From: Joanne Lewis
Sent: 29 May 2019 11:17
To: Planning.Responses
Cc: Anna Appleton
Subject: RE: Planning Consultation on BN/35/19/DOC

APPLICATION **BN/35/19/DOC**
NO:

Site Address: Land East Of Toll Cottage Lake Lane Barnham
PO22 0AD

Description of Works: Approval of details reserved by condition
imposed under ref BN/69/16/PL relating to
Condition No 20 - external lighting.

Pharola DS

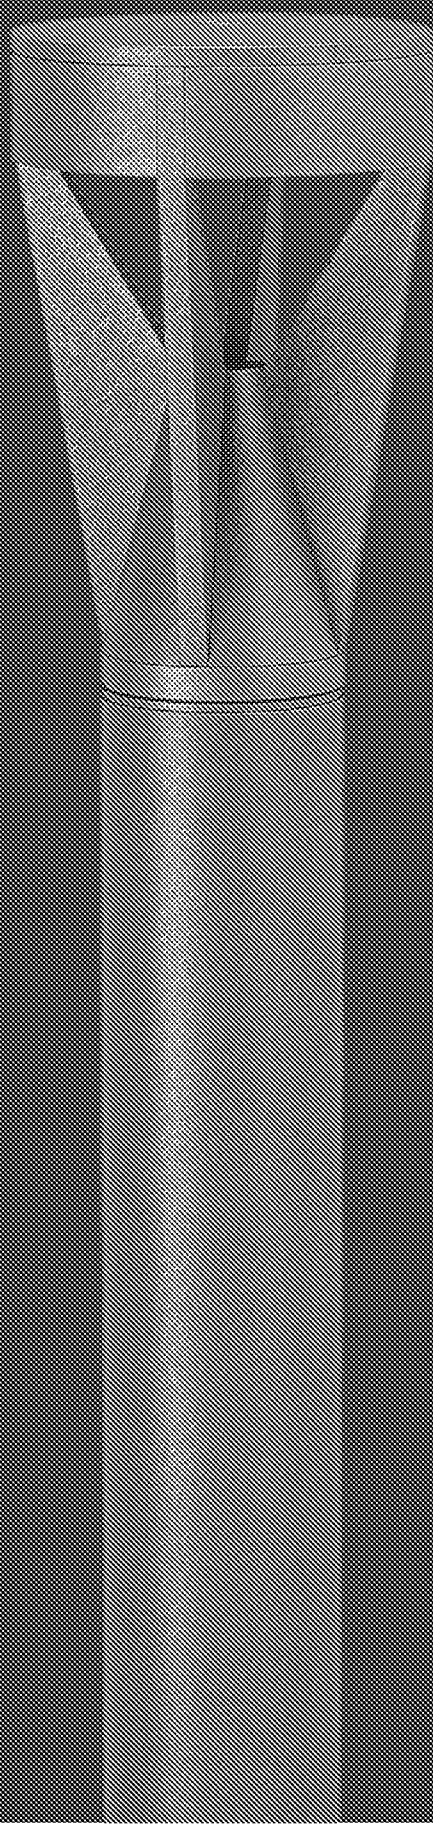
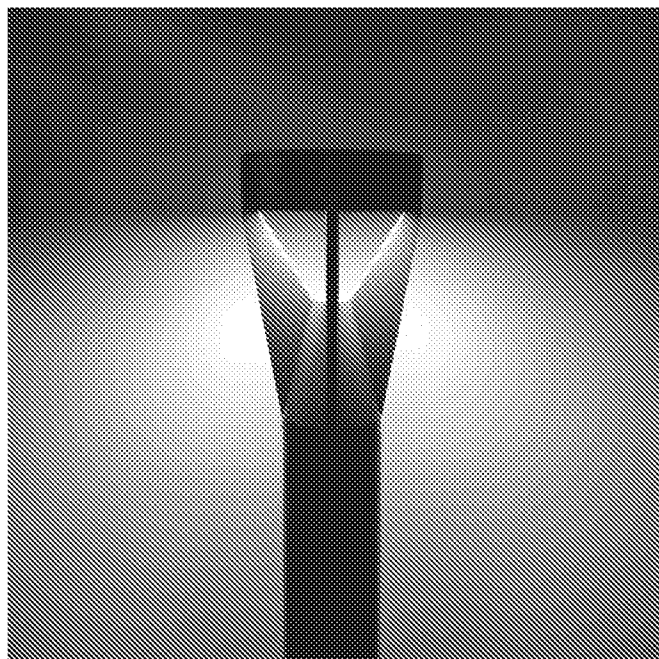
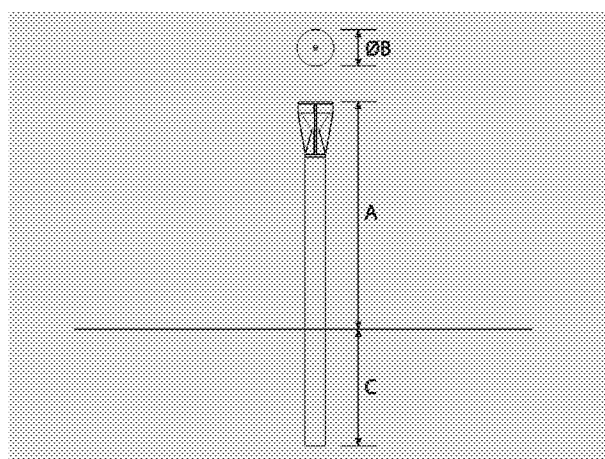
The submitted plan shows the location of the proposed lighting and the type of bollard and height of lighting, however there is no mention of illumination levels or light spillage. As far as I can tell the bollards will emit light sideways and not downwards which will not minimize light spill as required by the condition and could potentially affect residents and wildlife.

At this stage there is insufficient information for me to recommend discharge of the condition. I would need to see information on illumination levels and light spillage from the proposed lighting and justification as to why downward facing light sources are not being used and confirmation that the proposed lighting will not affect residents and wildlife.
